# City of Albuquerque

January 2, 2002

9001 Glendale

**RE: Building Permit vis-à-vis Lot 18, Block 16, Tract 1, Unit 3, North Albuquerque Acres**

ESB = 33'
Q = 115 cfs

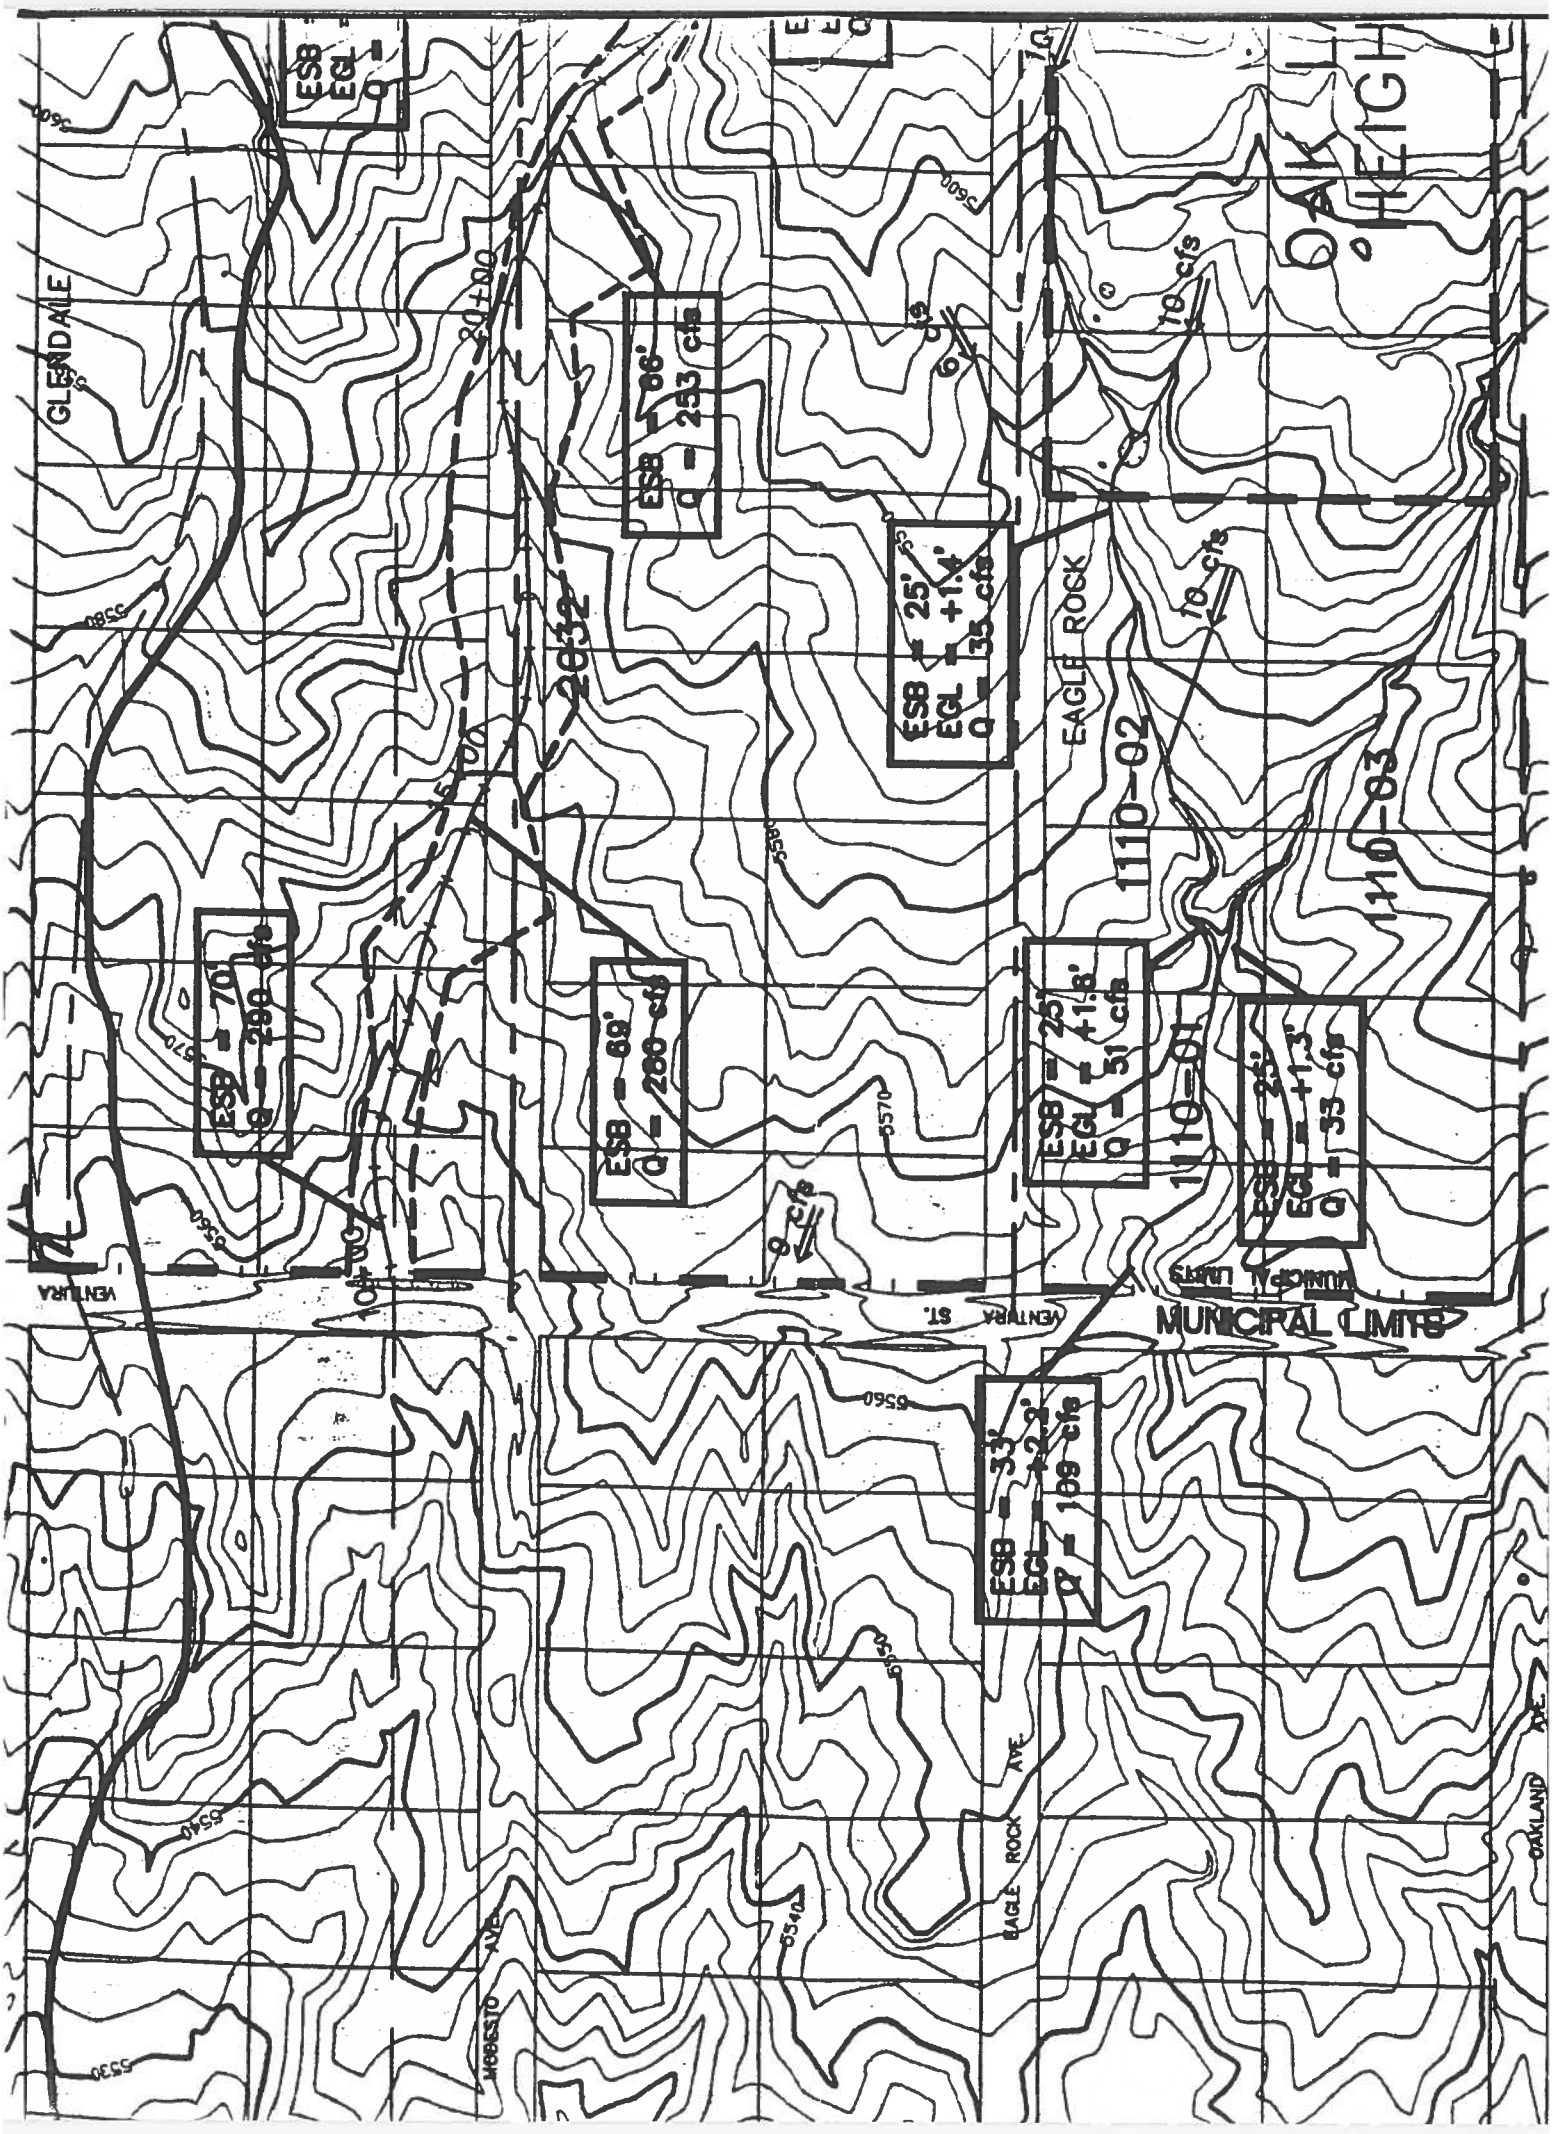
The 100-year floodplain is located adjacent to the south side of your lot on Glendale Avenue. The 100-year floodplain is that area impacted by the 100-year storm. The 100-year storm is precipitation within a six-hour period and resulting runoff that has a 1% chance of being equaled or exceeded in any given year.

The information above indicates that during the 100-year storm, the runoff within the floodplain adjacent to your lot is 673 cfs with a depth of 1 and 2 feet. Glendale Avenue, the road by which you access the property is clearly within the floodplain. Access to your property from Glendale Avenue during the 100-year storm would be extremely dangerous. The velocity and depth of the runoff could stall vehicles and carry them downstream. To mitigate the danger and protect against loss of life and property the City's Drainage Ordinance requires that an all-weather access road be provided to the property during the 100-year storm.

A building permit cannot be issued for this property unless a 100-year all weather access is constructed, or alternative ingress and egress is provided to the lot that does not cross the 100-year floodplain. Of course there would have to be legal access for the alternative access.
